Please ask for: Ms Iqraa Malik
Email: iqraa.malik@terraquest.co.uk
Telephone: 01212341390
Our Ref: M/79/21/HH
Your Ref:
Date: 16th June 2021

Application for Planning Permission for Works or Extension to a Dwelling

Development: Erection of single storey side extension, garage conversion to habitable use, alterations to fenestration/openings and internal ground floor alterations
Location: 18 West Drive Middleton-On-Sea PO22 7TS

Proposed Ground Floor Plan

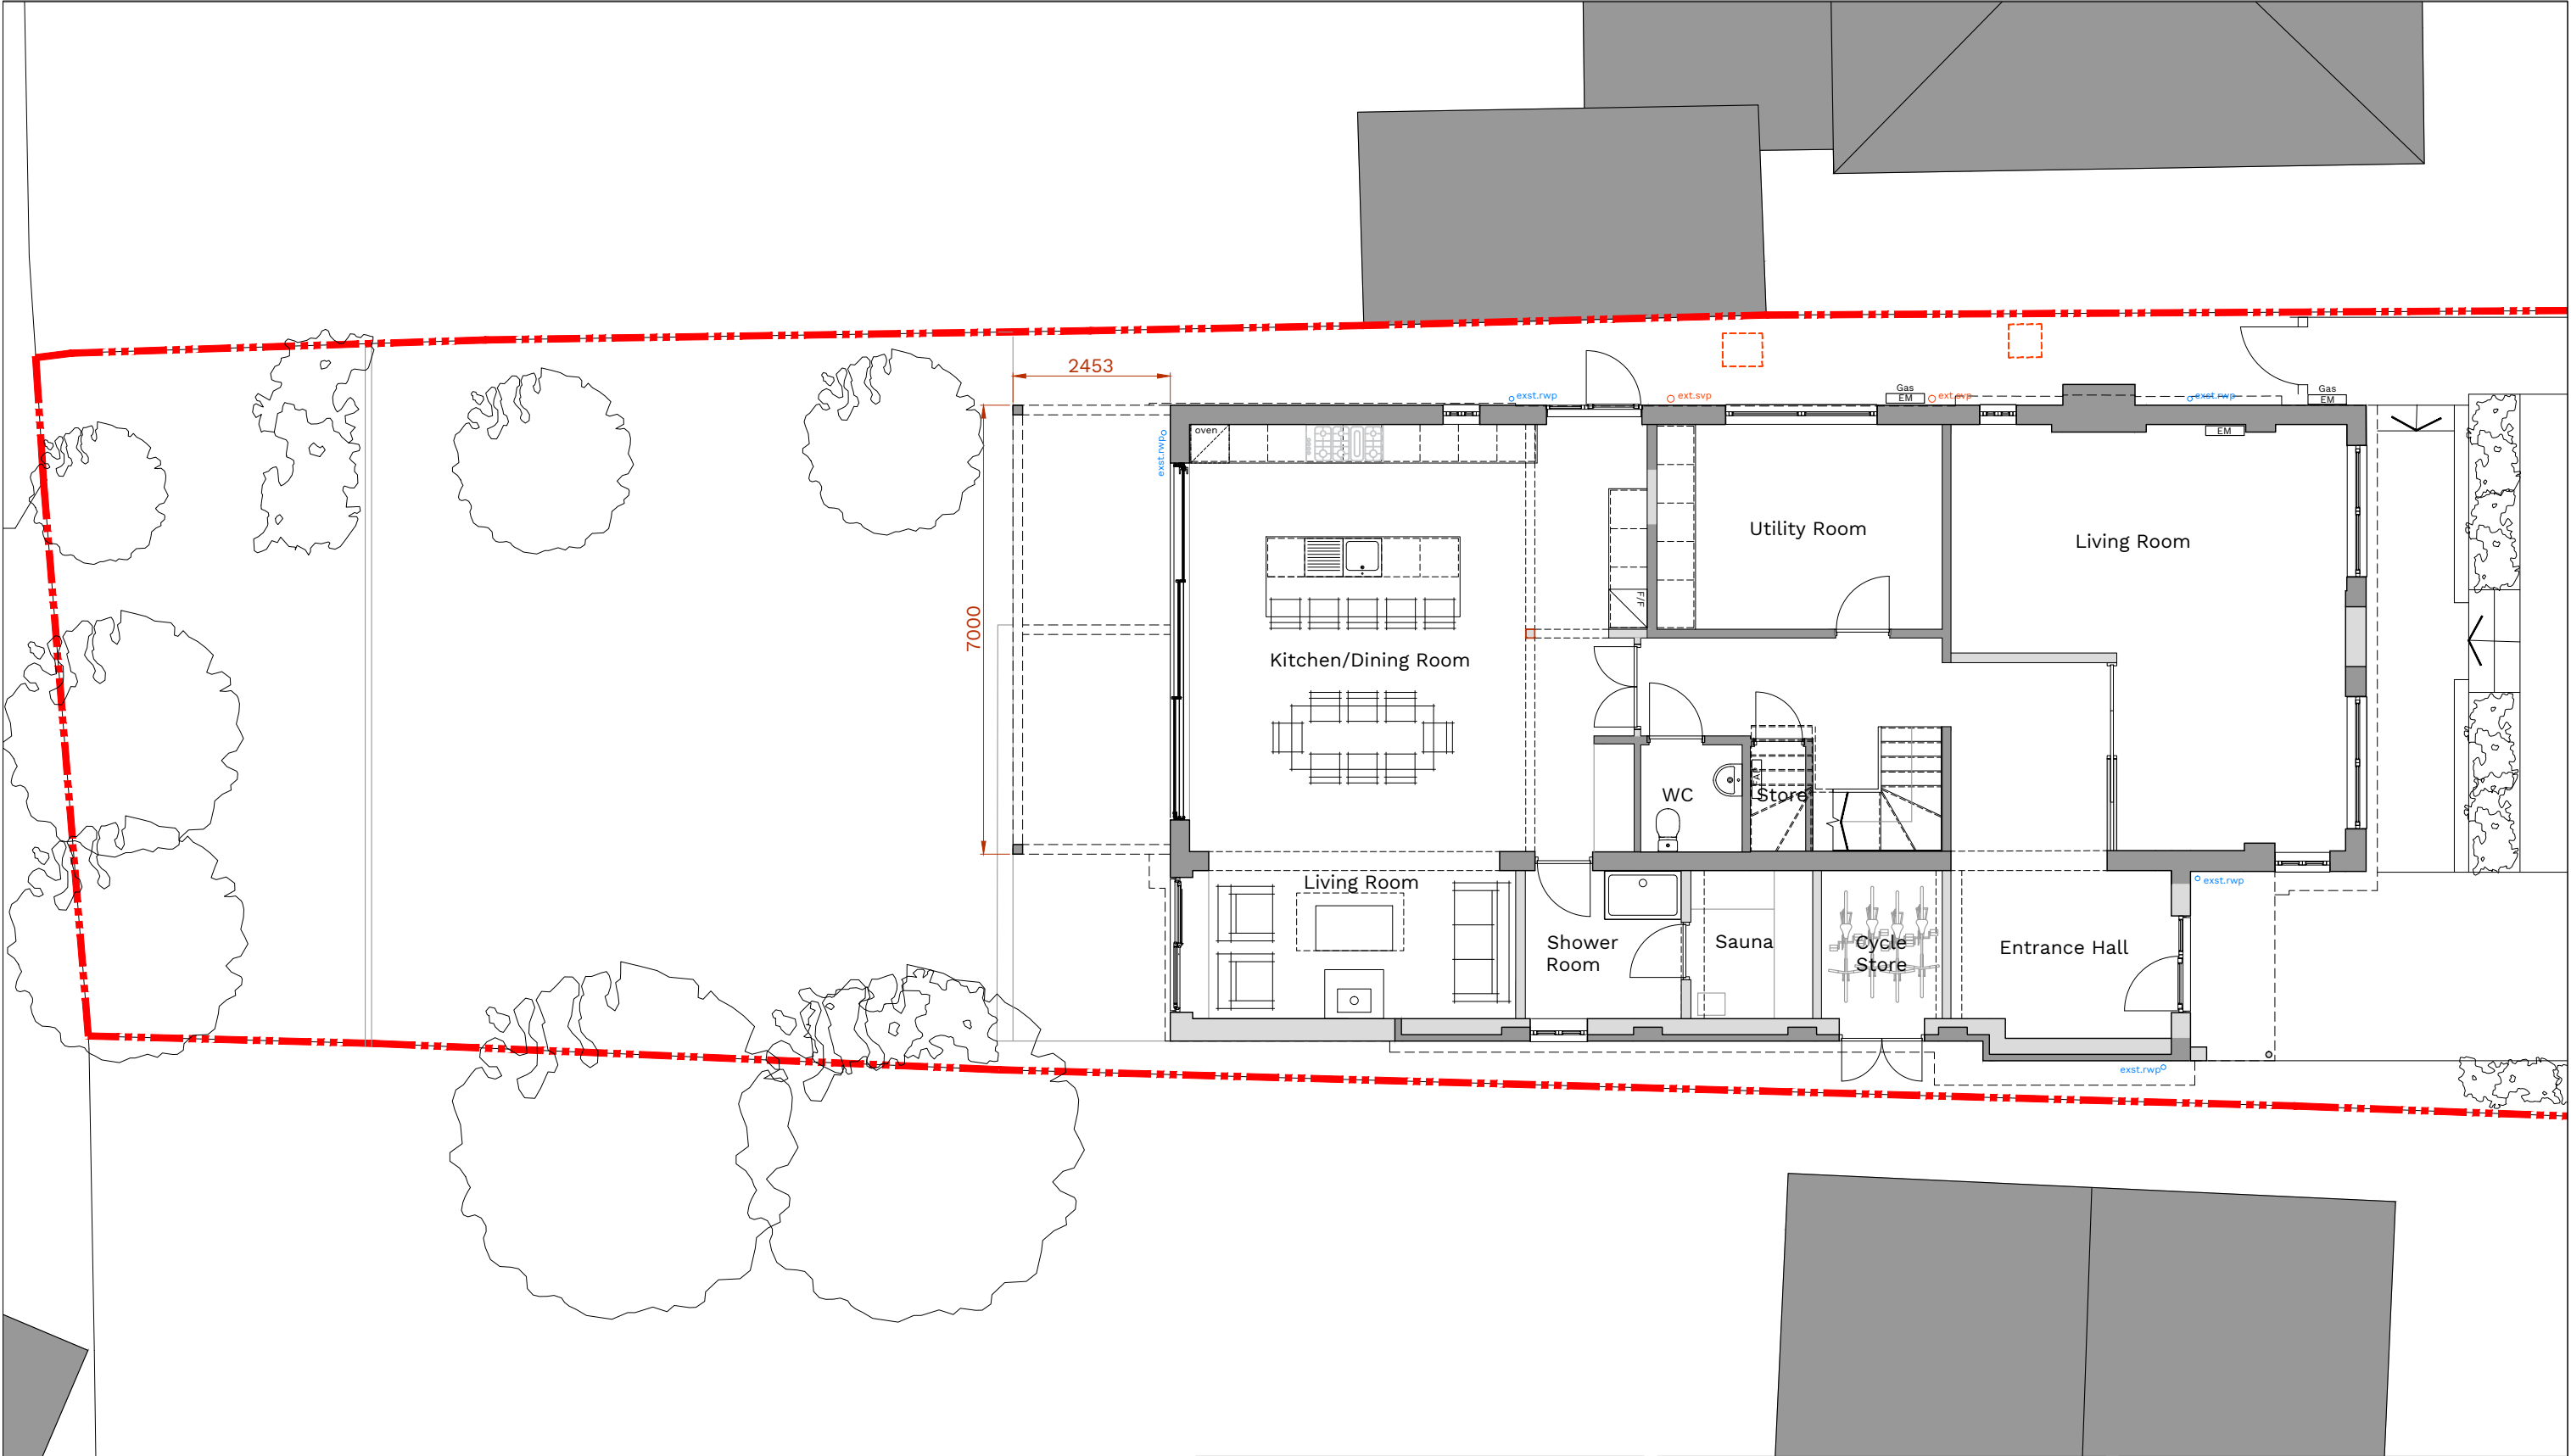
The cycle store door on the proposed ground floor plan is missing from the proposed south elevation. Please amend
